# Rezoning Transportation Analysis

Petition Number: 2024-004

**From: Jake Carpenter, PE**  
Jacob.Carpenter@charlottenc.gov  
980-221-5675

Date	Description
2-21-24	First Review (JP)
3-20-24	Second Review (JP)
4-23-24	Third Review (JP)

RZ-1.0

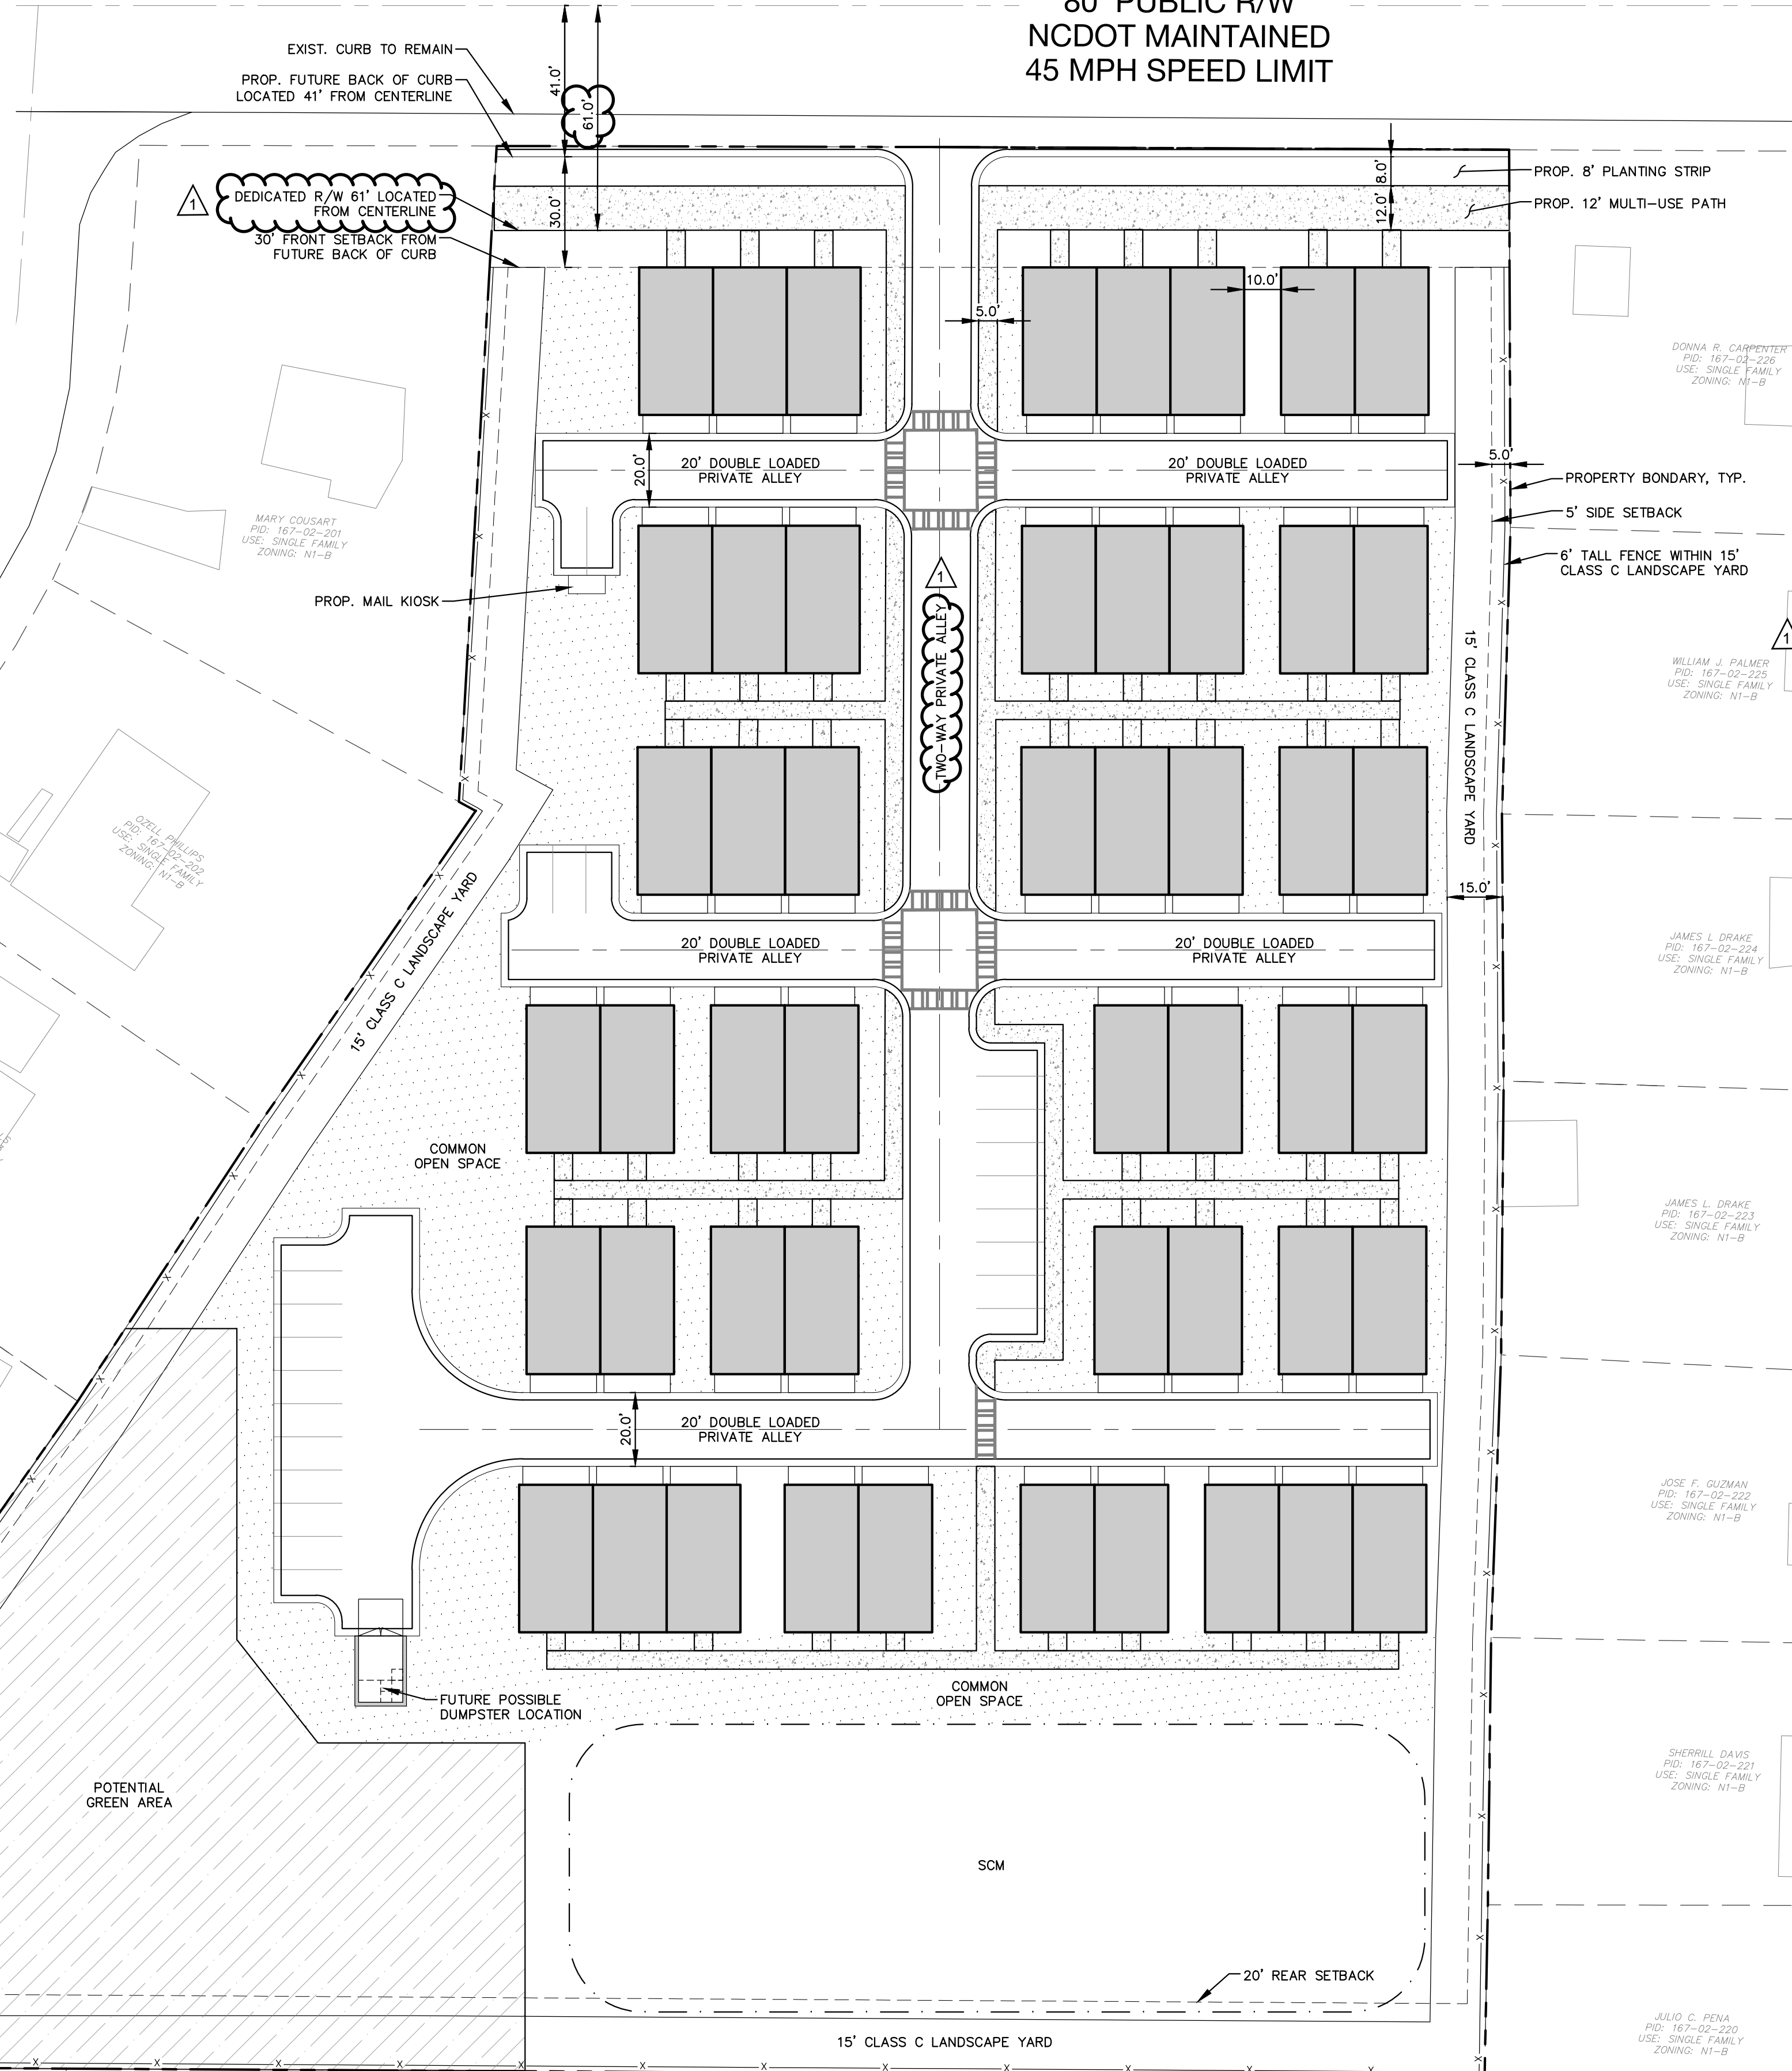
**1. ~~Curbline:~~**

- a. ~~South Tryon Street:~~ Location of future curb and gutter is 41' from the centerline for a 6+ avenue with a shared use path.

Label and dimension the curb and gutter from the centerline for each road on the site plan.

- 3. ~~Revise site plan and conditional note(s) to commit to dedicate 61 feet right of way from the road centerline. The site plan shall label and dimension the right of way from the road centerline.~~

- 4. ~~Outstanding Comment 3.20.24:~~ In coordination with NCDOT, revise site plan and conditional notes to install a right turn lane into the site with 50' of storage.

5. ~~Revise site plan to show the curb and gutter at the existing location. Due to the length of the sites frontage to South Tryon Street, the curb and gutter does not need to be relocated. Continue to show the future back of curb at its future location. Streetscape will be installed off of the future back of curb as shown.~~

**Clarifying Comment 3.20.24:** Just use one line to show future back of curb. Move the driveway cut and curb and gutter to the existing location.
